CITY OF ALBUQUERQUE

PLANNING DEPARTMENT – Development Review Services

January 27, 2016

**RE: Stanford Court (424 Stanford Drive SE)
Grading & Drainage Plan
Engineer's Stamp Date 1-7-16 (File: K16D084)**

TOPOGRAHIC DESIGN SURVEY

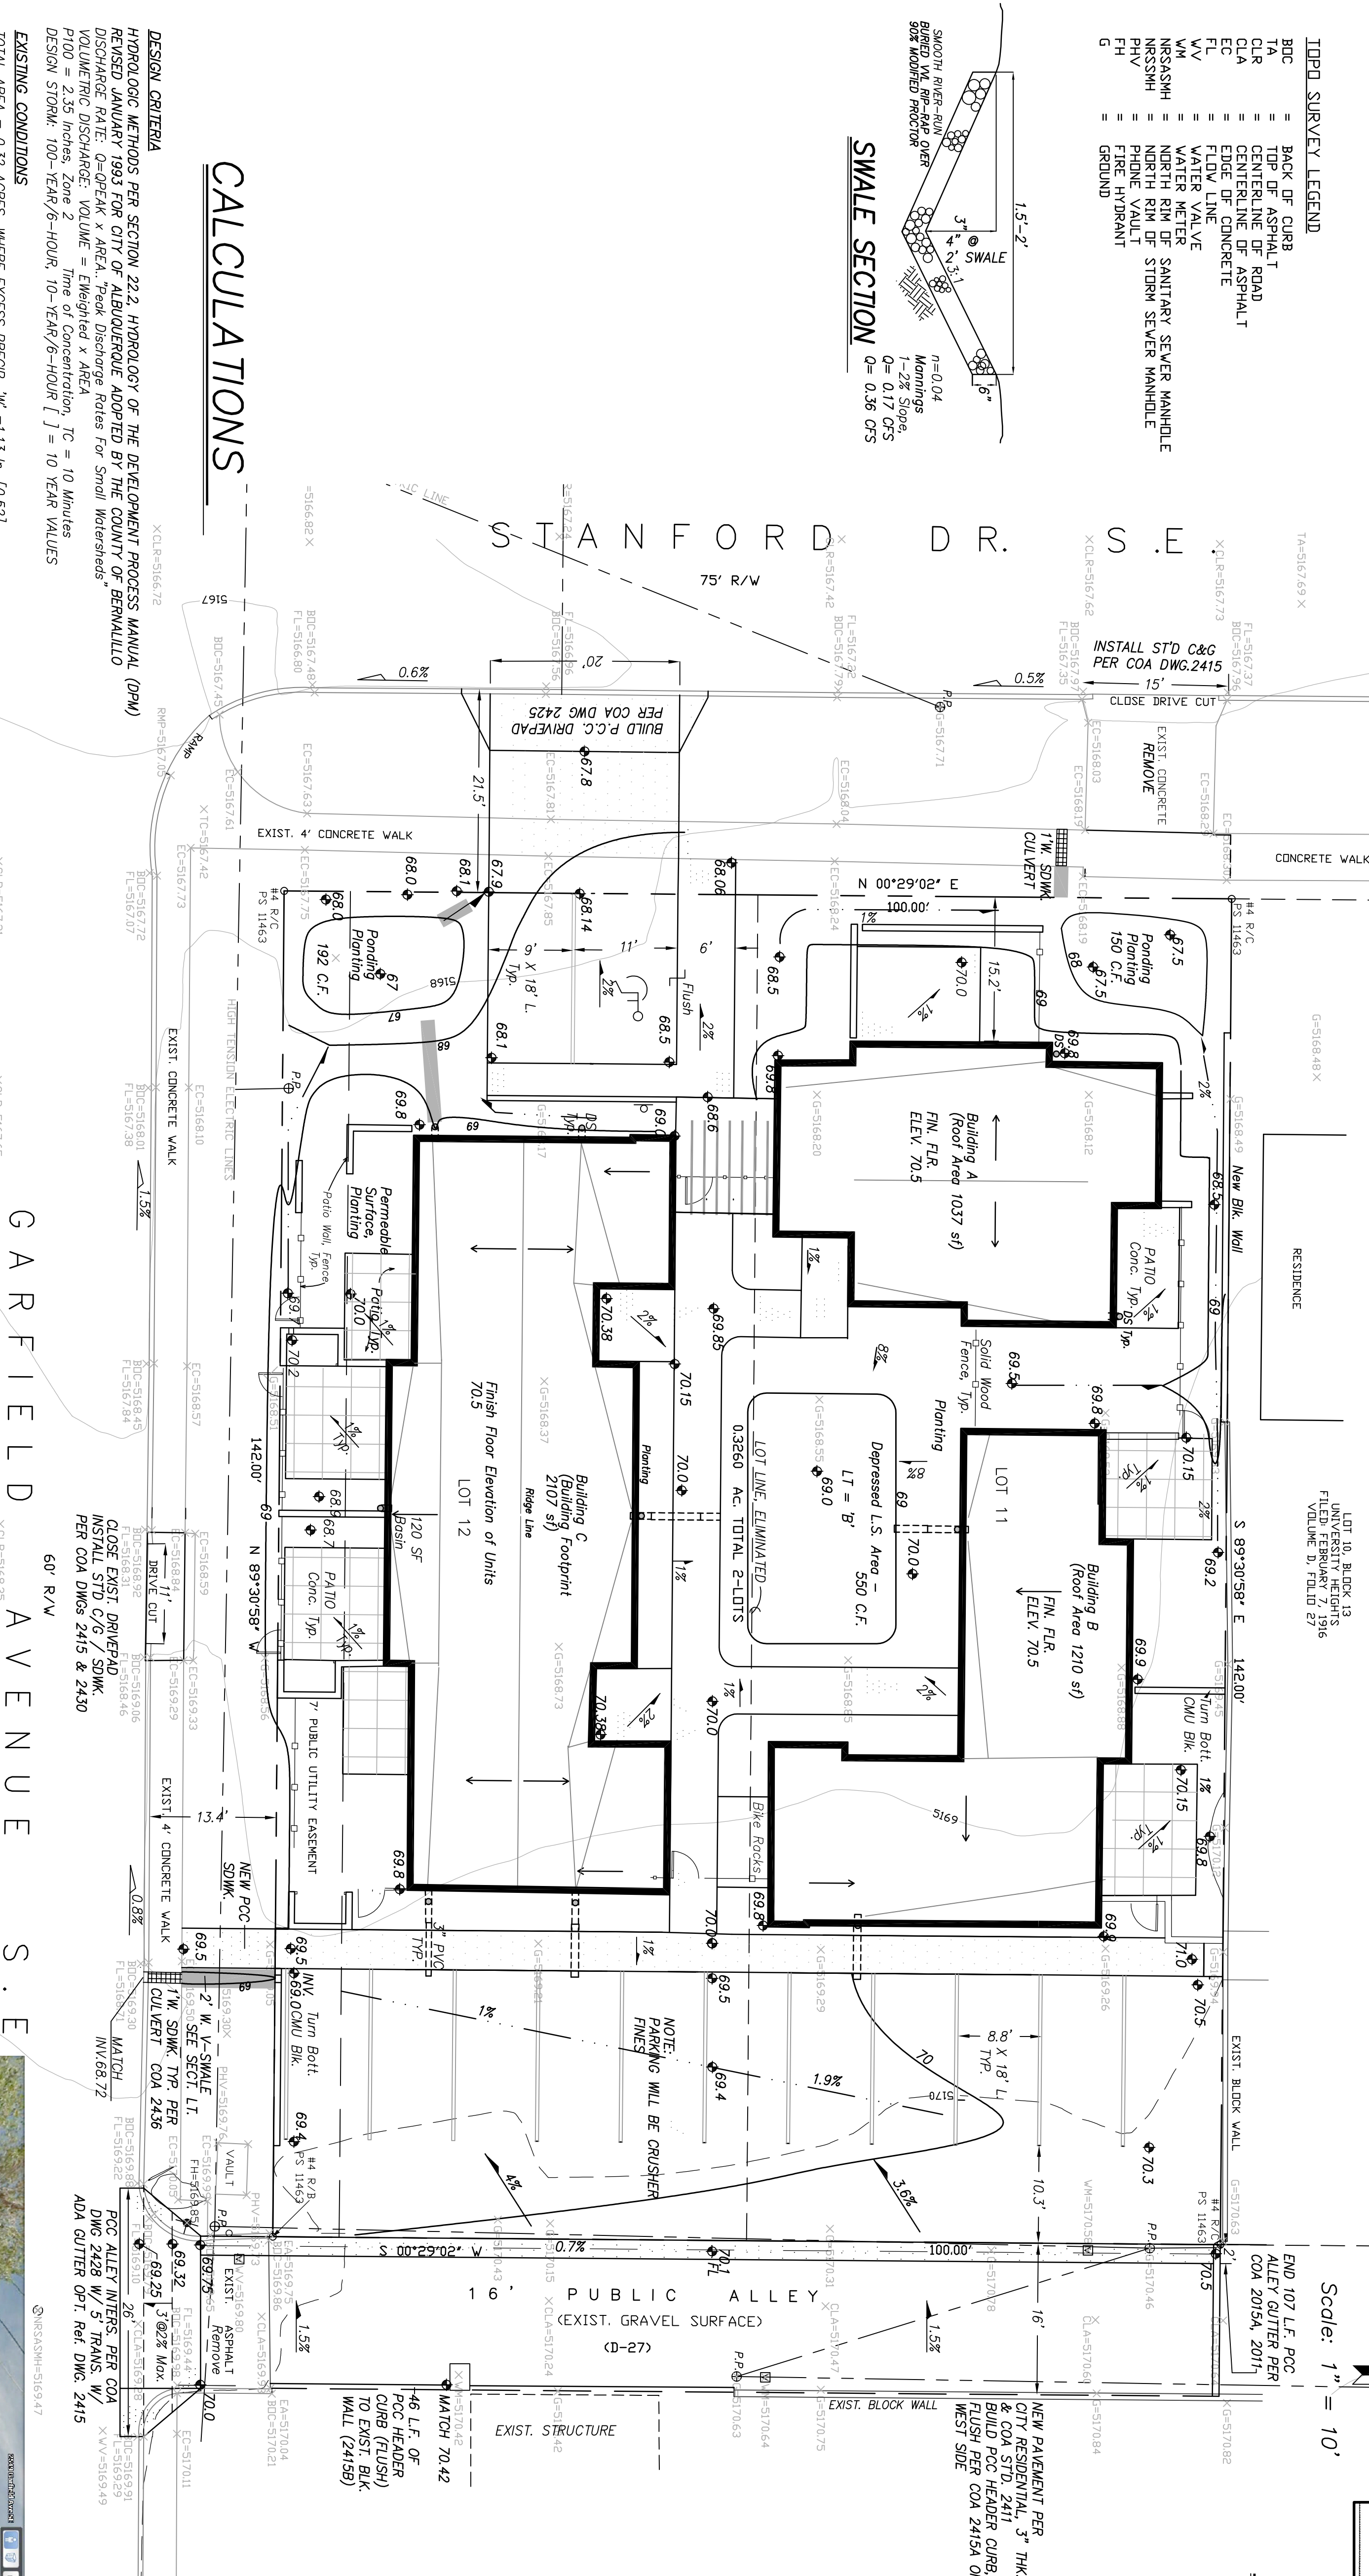
1. The Drainage narrative implies that a discharge slightly above historical values will be discharged onto the City Right of Way, but there are no calculations provided for the existing conditions

- a. The Drainage Plan states that free discharge of developed flow is acceptable since capacity exists downstream. Evidence, such as including references from applicable Master Plans, or referencing the capacity of downstream structures must be provided.

- b. The volume calculation of the 100-year, 6-hour storm should be 1821 cubic feet, not 1812 cubic feet (per a quick calculation completed based on the plan's land treatments and dimensions). Furthermore, it is not clear why these volume calculations are provided, they do not correlate with the proposed total volume provided.

2. The required first flush volume (approximately 210 cubic feet) appears to be provided for in the total ponding volume, but the calculation needs to be shown on the plan (0.34" times impervious area).

3. Provide additional sidewalk spot elevations around the courtyard area to make it clear to the contractor that positive drainage is intended on the sidewalk surface.

4. Sidewalk culverts should be used in place of the 3" PVC piping to drain the areas adjacent to the east faces of the buildings on Lot 11 and Lot 12. 3" piping in landscaped areas will clog easily and may saturate the soil that is very close to the footings of the buildings. Alternatively, the roof drains can be continued in a closed conduit under the

sidewalk, if practicable, and positive drainage away from the building needs to be shown.

5. The drainage from the parking lot is directed through the block edge wall into the east-west drainage swale.
 - a. The swale cannot be in the City's right of way.

- b. The pond at the corner cannot extend into the City's right of way.
 - c. The capacity of the proposed turned blocks needs to be shown.
 - i. A detail needs to also be included to ensure that the bottom of the turned block(s) is set to match the flowline of the upstream swale.

6. The ponds along the edge of the lot (adjacent to public sidewalks) need to have an emergency spillway (such as a sidewalk culvert), this work which would likely extend into Stanford and Garfield will require an SO-19 permit. The resubmittal should include the SO-19 Standard Notes (emailed along with this letter).

7. Show additional spot elevations and/or proposed min/max slopes for the enclosed patios to ensure that they will be built to drain. Only two of the patios show a 1% typical slope across the concrete surface.

10. A cross-lot drainage easement between the lots will be needed, since the ponding areas and swales are shared-use facilities that transfer flows between lots. AC 1/27/2016
